From: Sarah Griggs <sarah.griggs@bvconsulting.co.uk>
Sent: 26 January 2023 16:46
To: Garry Griffiths; Dax@nordia-homes.com; Ross@nordia-homes.com
Cc: james@violet-homes.co.uk; Ross Thornton; stonejdb@outlook.com; nick@nordia-homes.com
Subject: 2022/93376 - Station Road, Meltham - LLFA and Highway Comments
Attachments: 1309-900P3 Drainage Layout 1 of 2.pdf; 1309-902P1 Hard Paving.pdf; 1309-700P1 Flood Routes.pdf; 1309 Trench soakaway for Plot 1 130 sq.m 100 year +30%CC RevA.pdf; 1309 Trench soakaway for Plot 7 98 sq.m 100 year + 30%CC RevA.pdf; 1309 Trench soakaway for Turning Head 220 sq.m 100 year +30%CC.pdf; 1309 permeable pavement 50sqm Plot 3 100 year +30%CC RevA.pdf; 1309 permeable pavement 60sqm Plot 7 100 year +30%CC RevA.pdf

Rev	P1	Number		1309-902
Date	Jul 202	Checked	Drawn	Scale 1:200@A1
			SUG

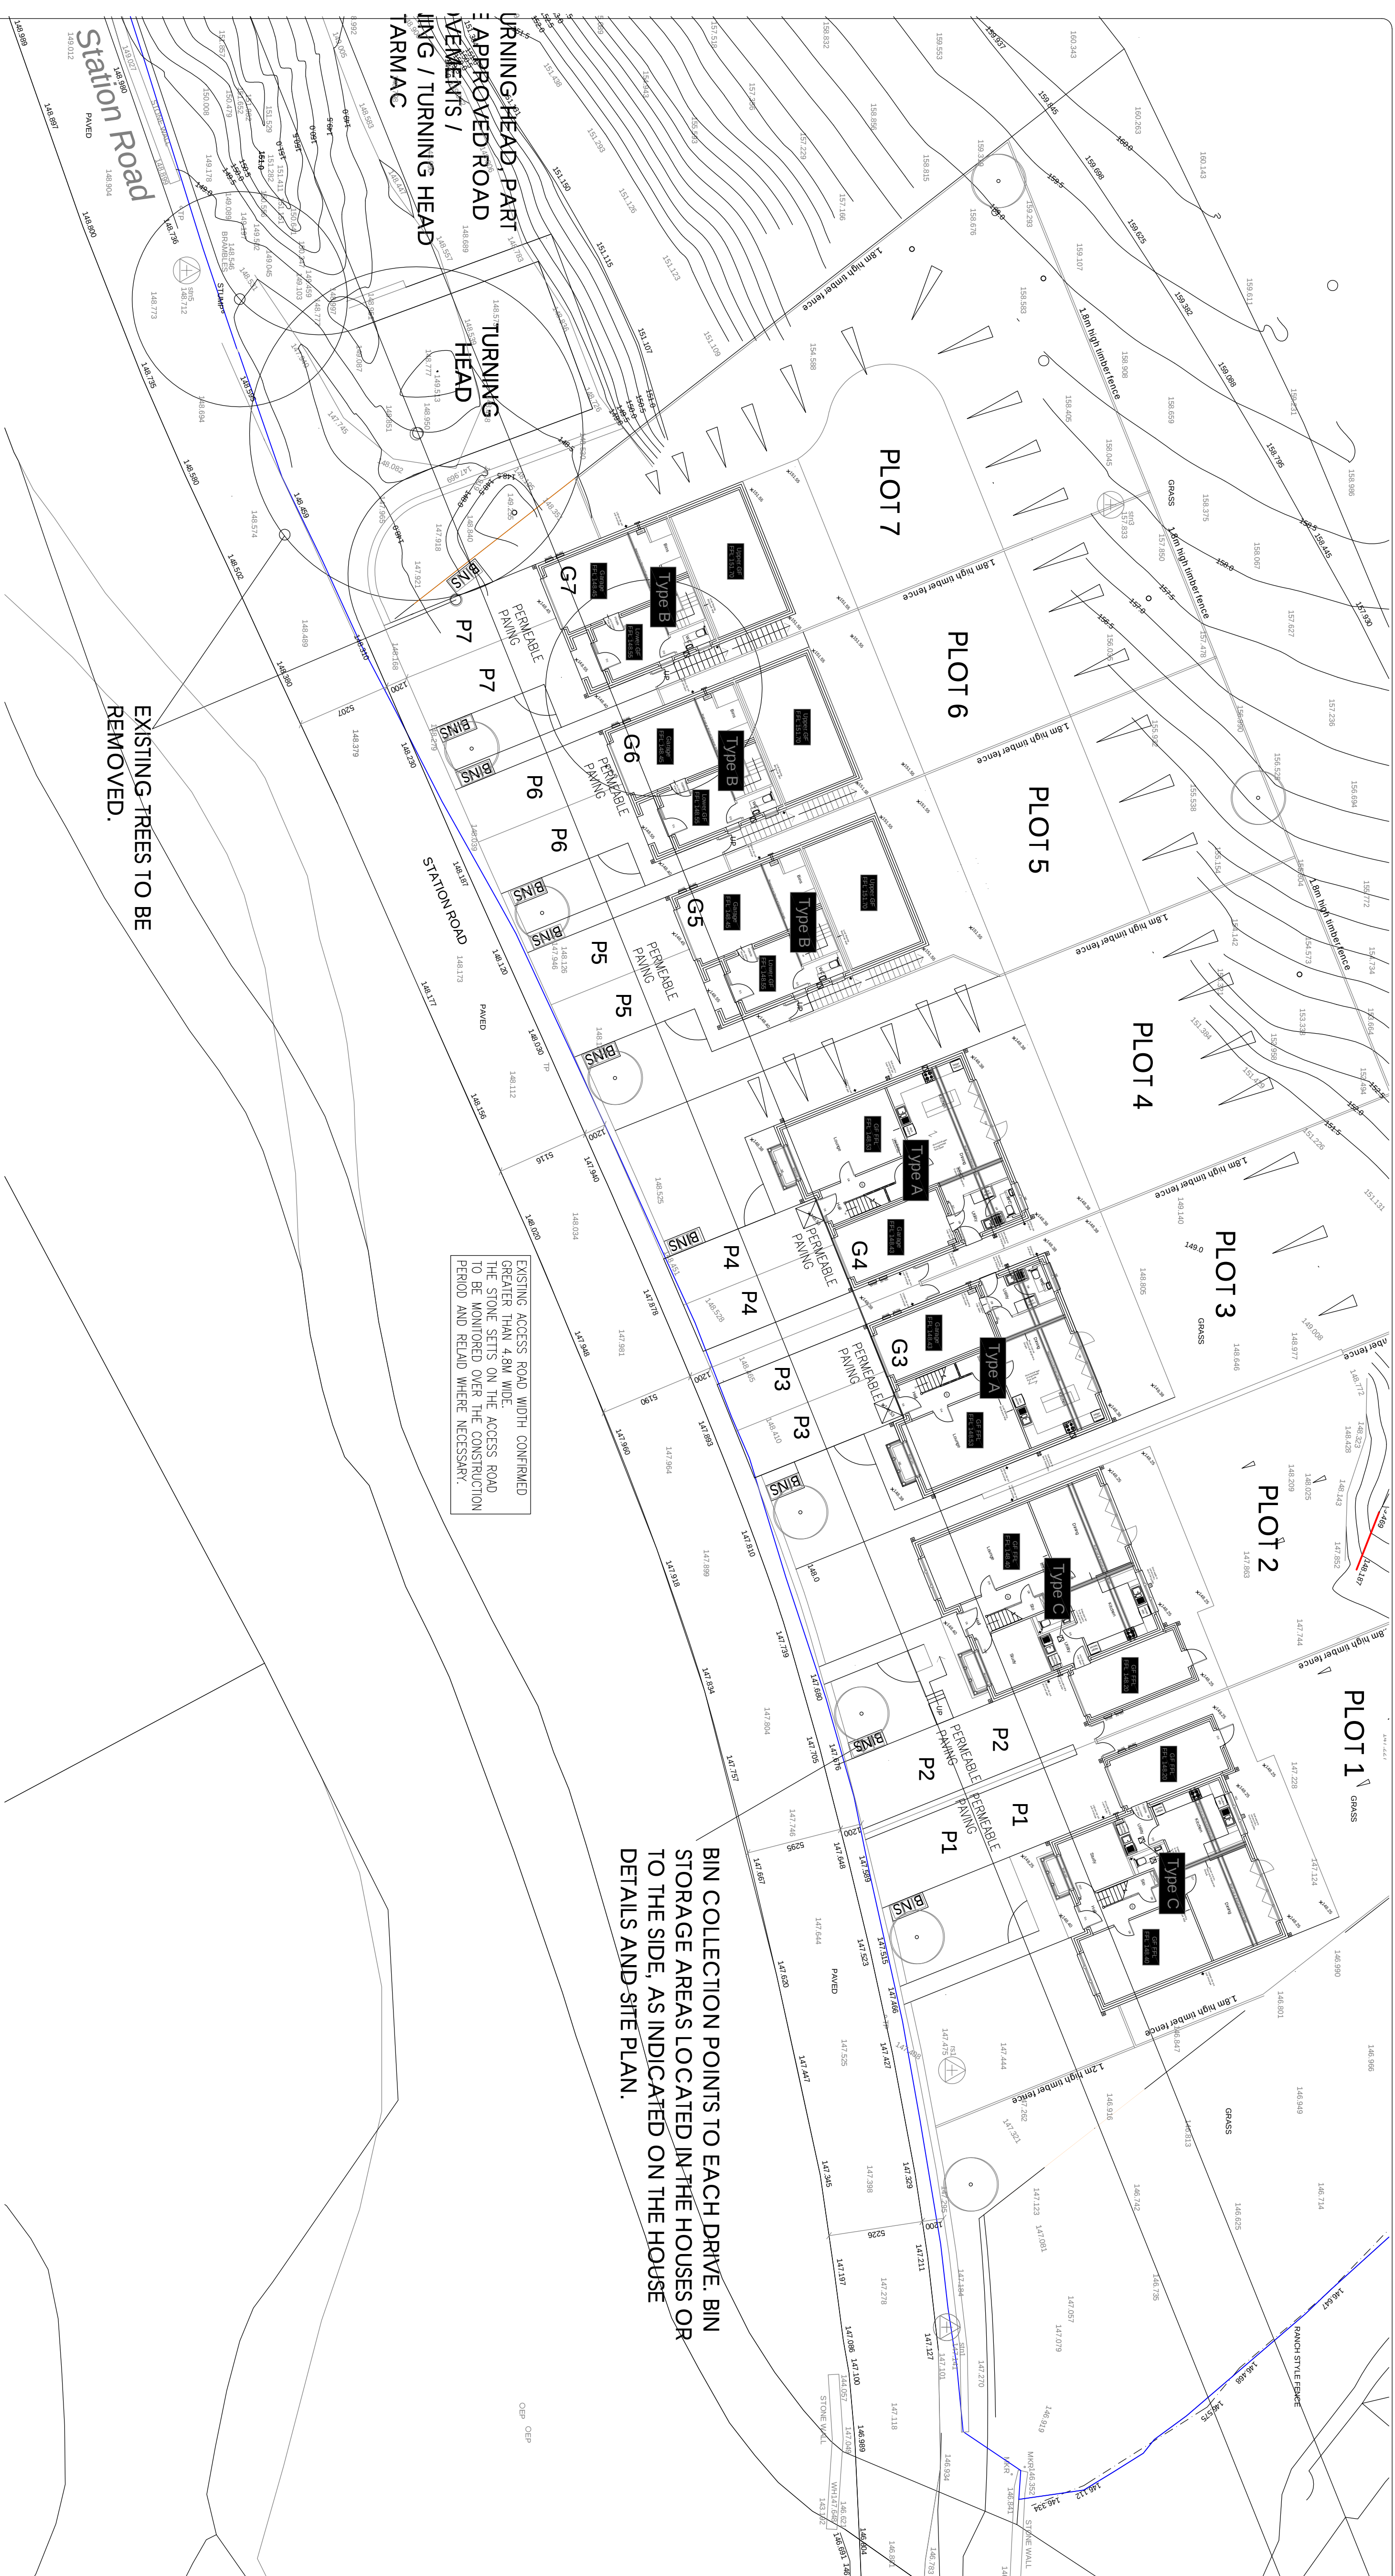
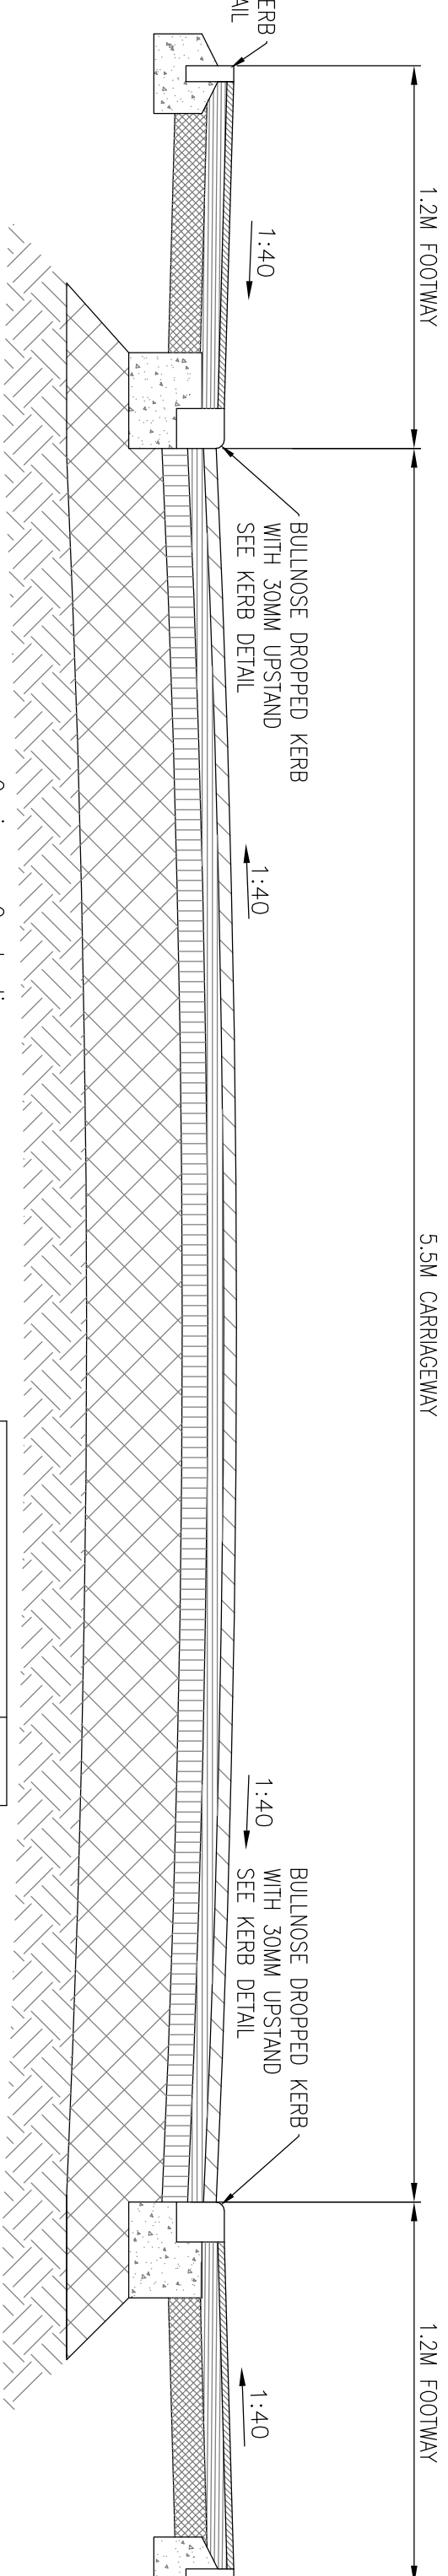
With regards to the highways comments, drawing 1309-902P1 doesn't show the access road Station Road being widened as stated. The new topo survey confirmed Station Road is wider than thought previously as it was overgrown, the widths 5116mm to 5295mm are dimensioned on the drawing and as its wider than the 4.8m requested previously, widening of the road isn't required. Drawing 1309-902P1 attached notes 'Existing access road width confirmed greater than 4.8m wide. The stone setts on the access road to be monitored over the construction period and relaid where necessary'. The stone sett permeable pavement access road detail shown also notes '..(If required - to be monitored over the construction period)'.
